Final Report - Corrections Required **Application No. ZONE-25-0021**

Record Type : Zone Change

RE: BLR Village C
Land Use Plan (LUPL-25-0008 formerly PDZL-24-0005)
Zone Change (ZONE-25-0020 & ZONE-25-0021)

### AVIGATION EASEMENT STATEMENT

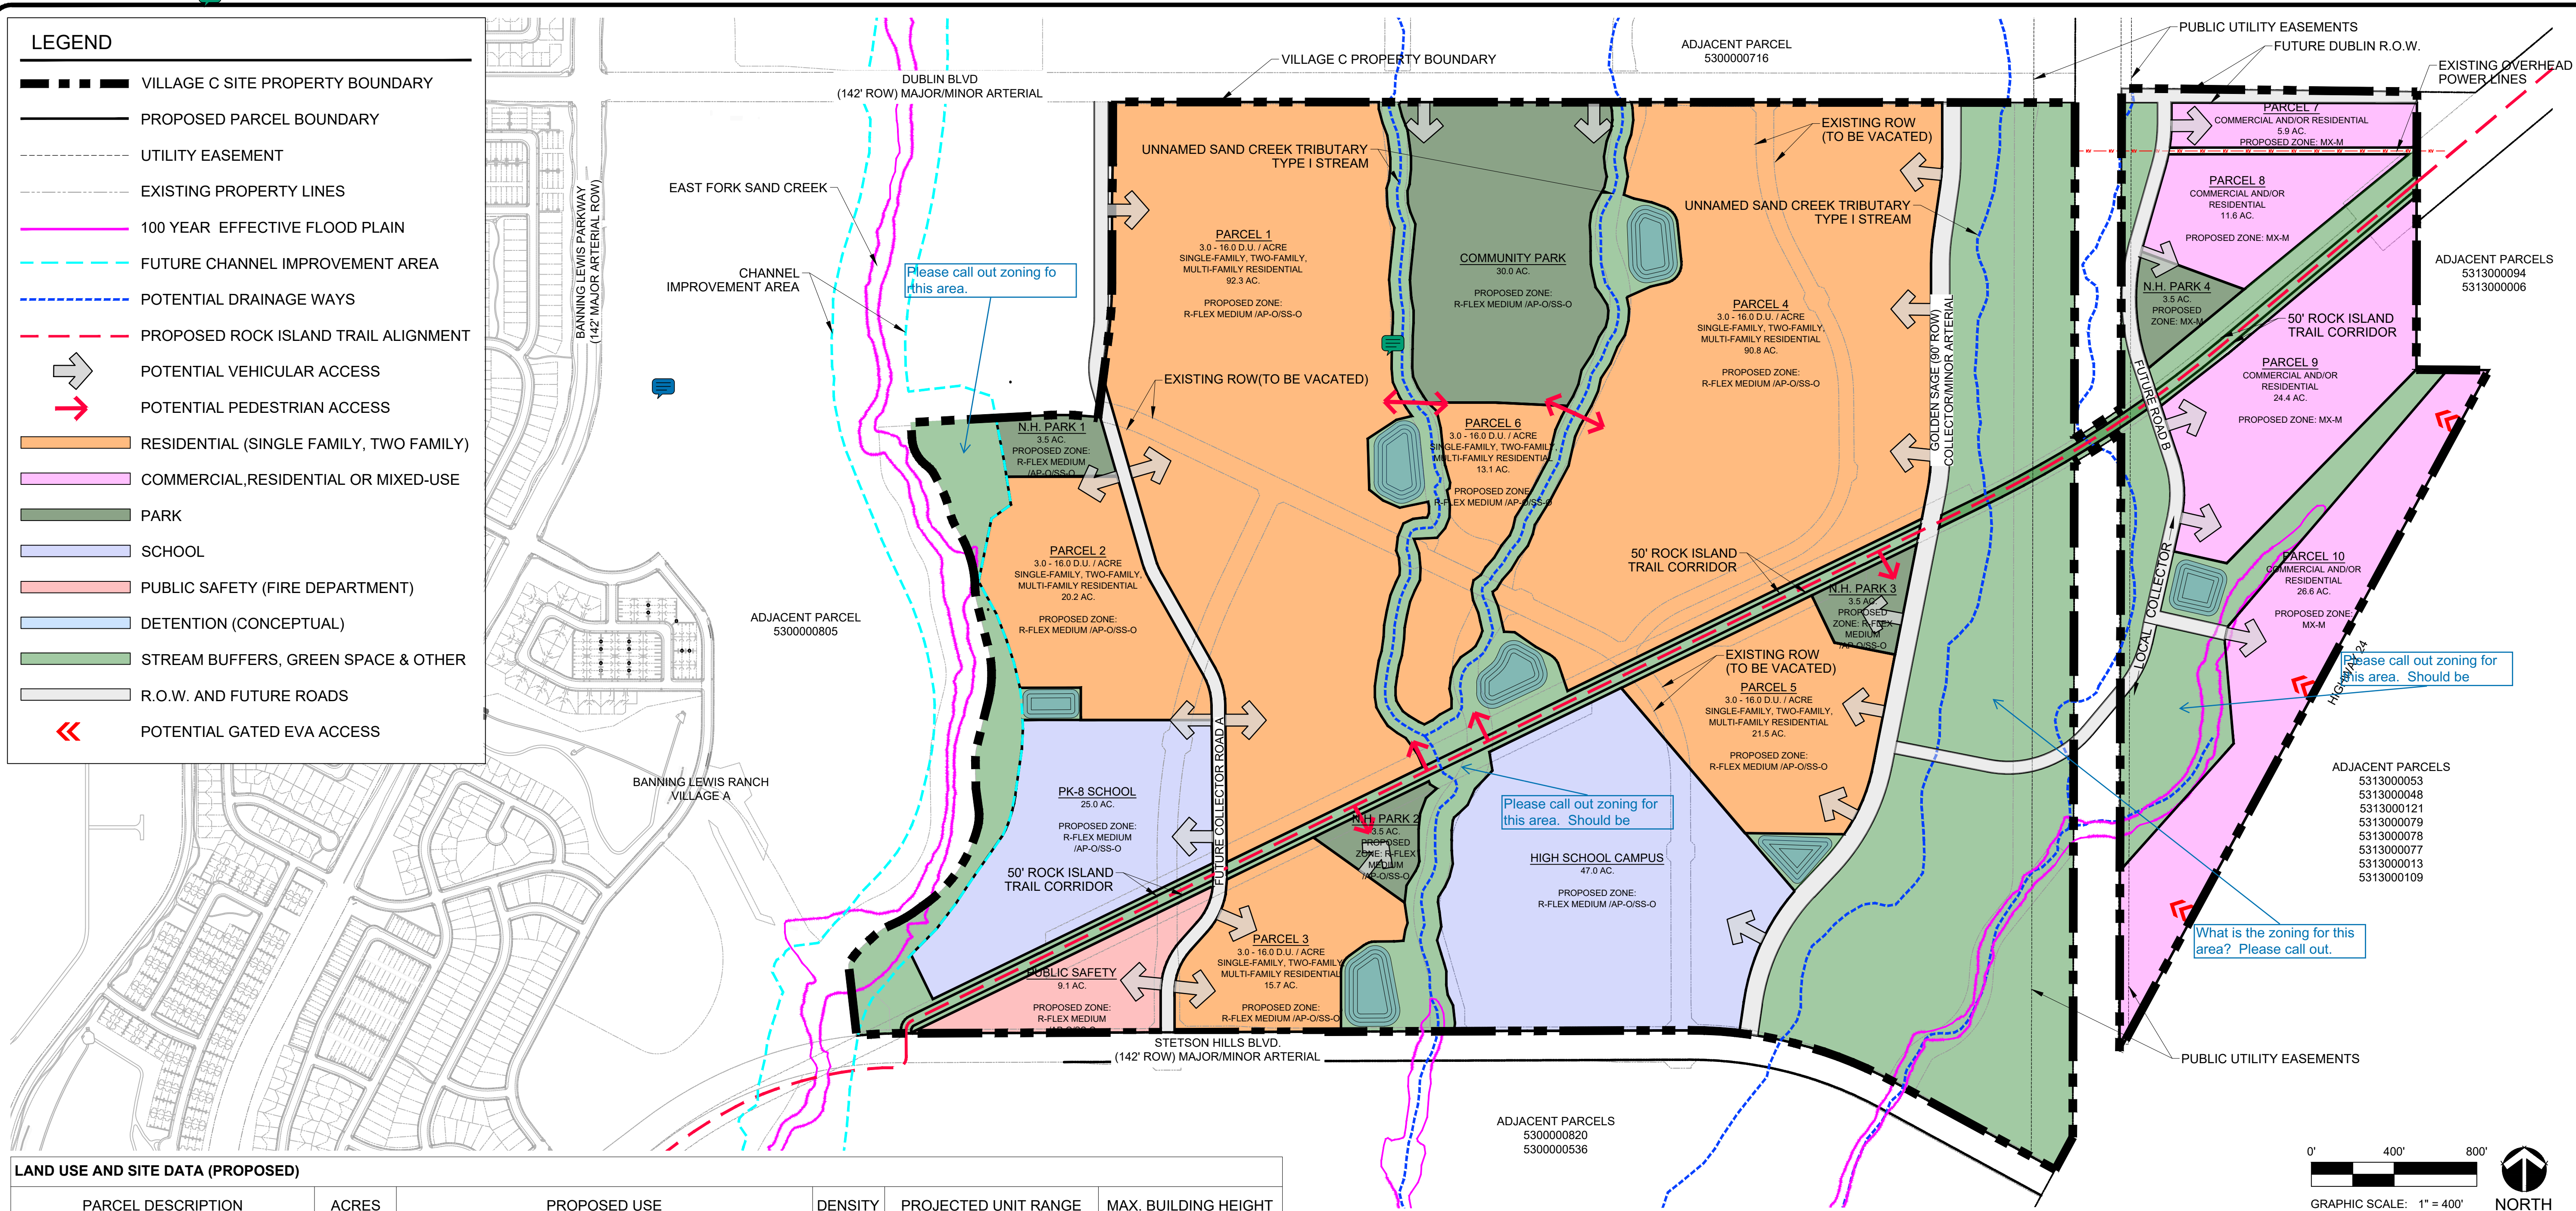
Comment ID	Reviewer : Department	Review Comments
24	Teresa Guagliardo : CDOT	Please refer to the letter emailed to Tamara Baxter on 11-24-2025 for CDOT's comments regarding this development.
20	Chris Padilla : COS Airport	Action Items: 8/4/2025: This action item was approved by the AAC, please provide proof of Avigation Easement. This item will be reviewed by the Airport Advisory Commison on 7/23/2025 with the below action item for Parcel # 5300000733. • Avigation Easement: An avigation easement is required or provide proof of previous recording (book/page or reception number). Add avigation easement note to plat.
